OBSERVATION/SUBMISSION TO PLANNING APPLICATION

Case Reference: 323761

Re: Observation/Submission to proposed wind energy development at Cooloo Wind Farm

Applicant: Neoen Renewables Ireland Limited

Figure 15-6b Proposed cable route and potential diversion routes

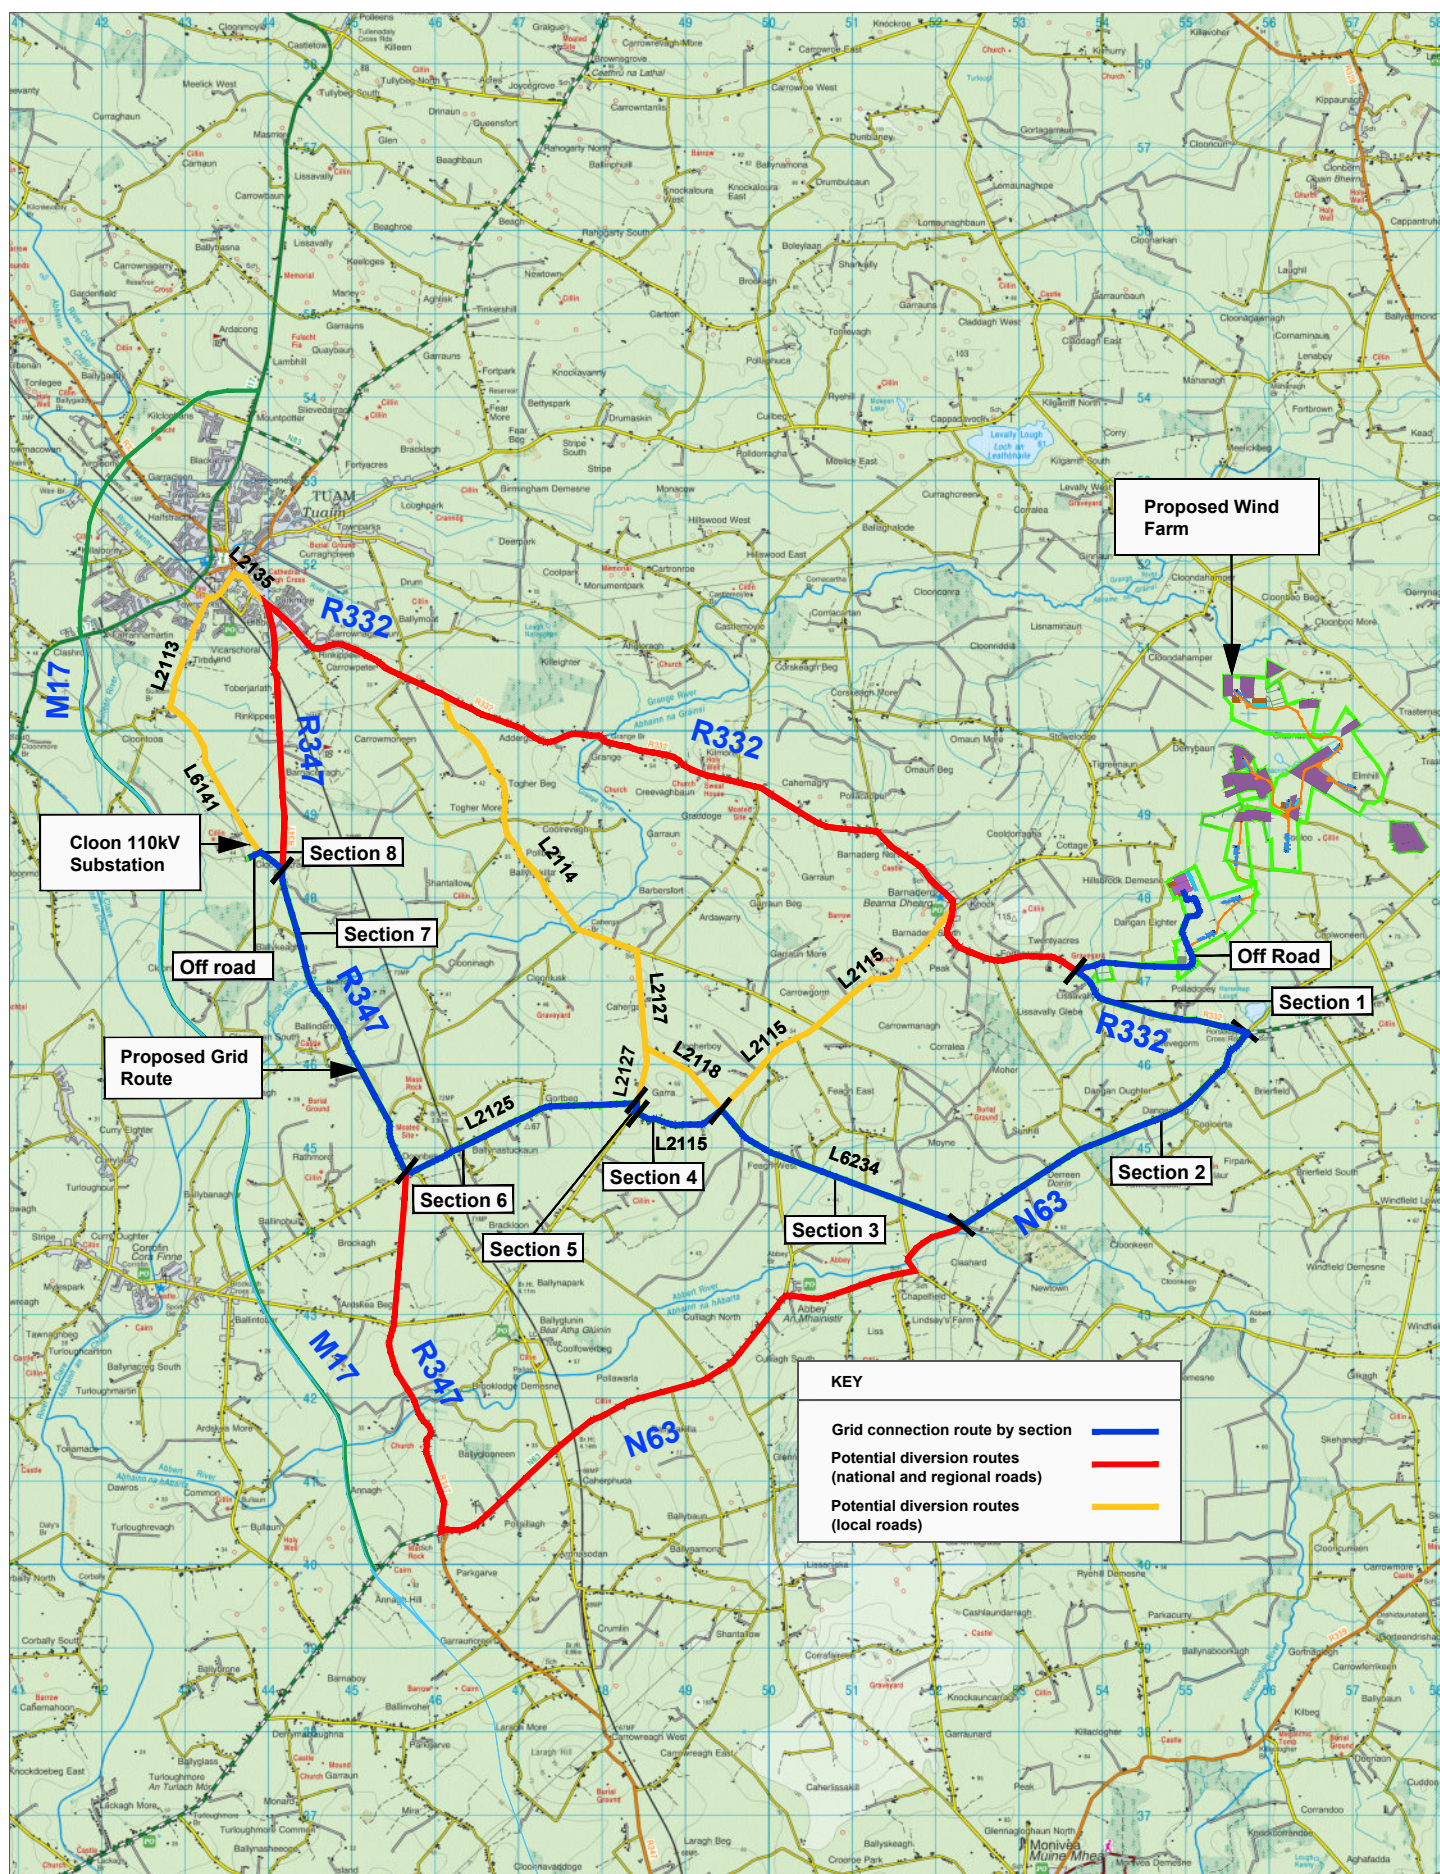
This submission objects to the proposed development due to insufficient traffic management and risk assessment in Appendix 15-2 (Traffic Management Plan). The plan omits essential quantitative data—such as expected abnormal load numbers, peak-phase traffic volumes, and route-specific scheduling—required to evaluate construction impacts. Narrow rural roads near Barnaderg and Cooloo lack the capacity for large turbine transport without pre-works strengthening or verge reinforcement. No detailed programme for road condition monitoring or reinstatement is provided. The TMP also fails to model cumulative or worst-case haulage scenarios, nor does it include enforceable mitigation measures for school transport, farm access or local business continuity. In the absence of these specifics, the project's potential impacts on road safety, infrastructure integrity and rural amenity remain unacceptably high. The application states that locals will kept informed about traffic construction. Judging by how poorly locals were informed about the windfarm initially, I would be very sceptical as to whether we would be kept informed once construction was to commence. The Board should refuse permission or impose strict, verifiable traffic and haulage conditions.
